Ref: BR/82/22/PL

RE: 'Plans for the demolition of the existing buildings & the building of 10x flats/apartments at the rear of Holmlea & Merryfield Town Cross Avenue Bognor Regis PO21 2DN'

Proposed Apartments
Planning

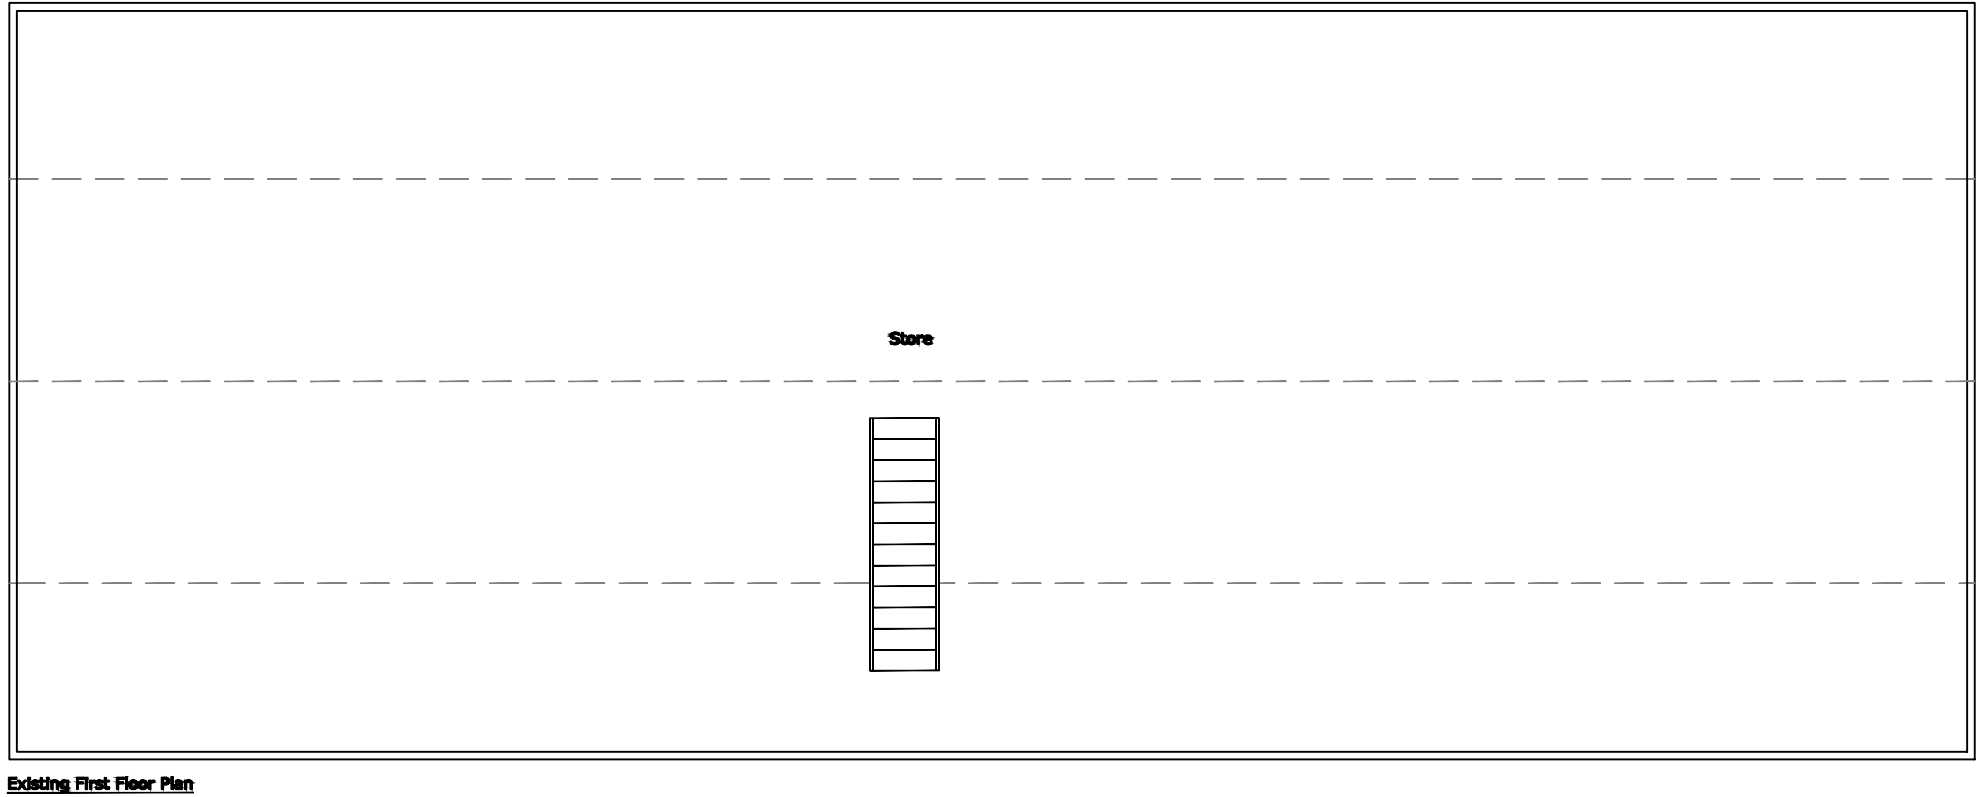
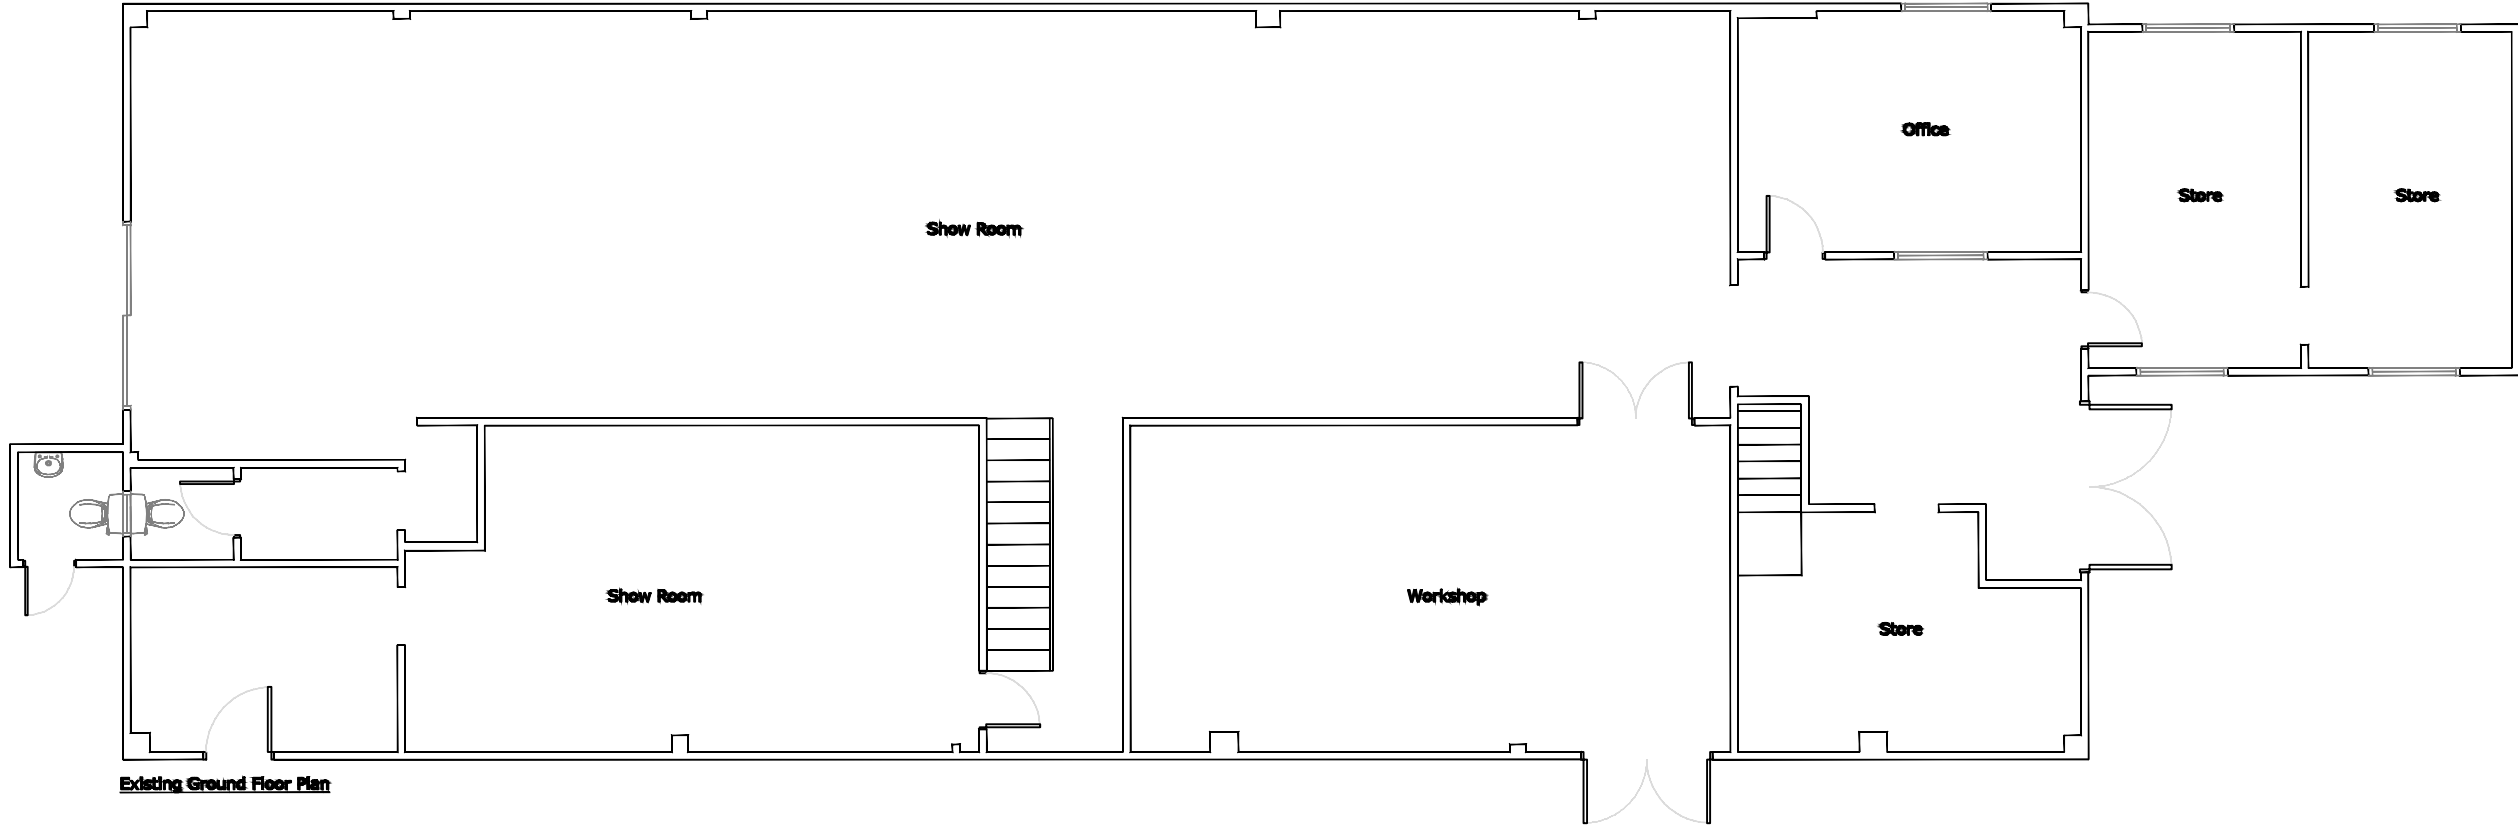
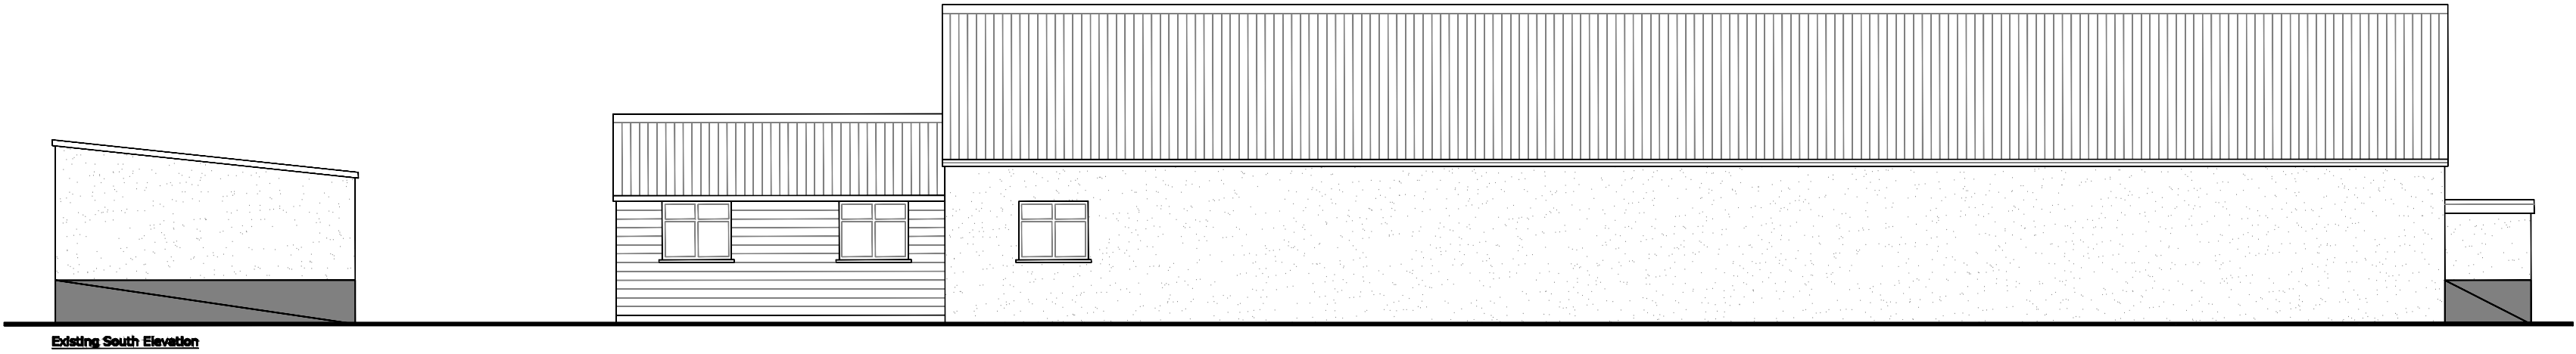
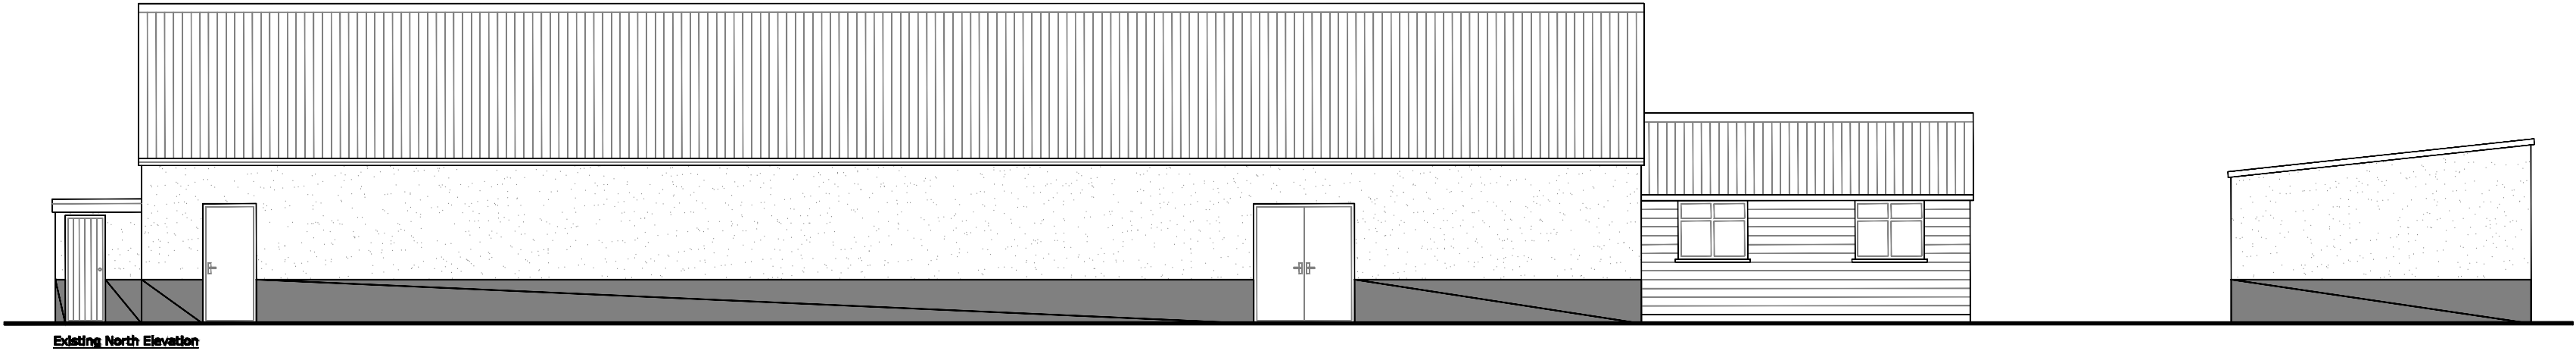
- Lack of parking for vehicles (cars) – there are 10 flats proposed and only 8 parking spaces, the average number of cars per household in the UK is 1.21 meaning there will be an average increase of 12.1 extra cars produced by the flats, and then take the 8 parking spaces away, this will leave an average extra number of 2.1 cars, where will these park? Probably down our already congested road (Town Cross Avenue).

- We would therefore need some sort of increased boundary for security (higher fences/walls or security boundaries etc.).
- Lack of privacy, overlooking of Essex Road gardens – the three story property (windows) will be facing many of the gardens of Essex Road with only a few metres between them.

- Blocking out of even more of our sunlight (reduced daylight) - the existing buildings are currently only one story high (having a flat roof near Merryfield & Holmlea) and the proposed flats will be 3 including their roof. Since we have had 4 houses build next to Merryfield on a 1x bungalow sit sunlight has been greatly reduced and this would decrease the sunlight even more – being very unfair.

- I would suggest the building be not as large, say 1-2 of the central sections (if you divide it in 5 sections) be removed lessening the width of it by 1 or 2 whole sections and kept to the far end thus giving more parking and less flats.

- The area is very small for 10x flats and 8 parking spaces – I feel it will look and feel very squashed together and will be a large building surrounded by houses and rear gardens.

- Suggestion is less flats and more parking or open spaces around them.
- New road will be too slim and very close to the side of Holmlea - the road to access to the flats is on the side of my next door neighbour's home (Holmlea). This will cause her added noise and disruption as with the increase of cars etc. Also, the road itself will be extremely slim, less width (barely enough for a van) and I would fear for my home (damage to building walls) and fences with increased traffic from the new flats, if I were her. Also, on a safety issue would a fire engine be able to access it if needed or even get close to the large building?

- I would therefore require less flats and more parking for them (less greed and more neighbourly consideration).
- Security issue to the rear of our gardens - as this is currently a commercial unit it has locked gates at the bottom of the mini road next to Holmlea and security cameras. If the proposal is completed this will be an open road and access to Merryfield and Holmlea as well as many gardens down Essex road.

- I would therefore suggest the need of an increased boundary say higher fences/walls or conifers and/or a reduction of high to 1 or 2 story flats etc.
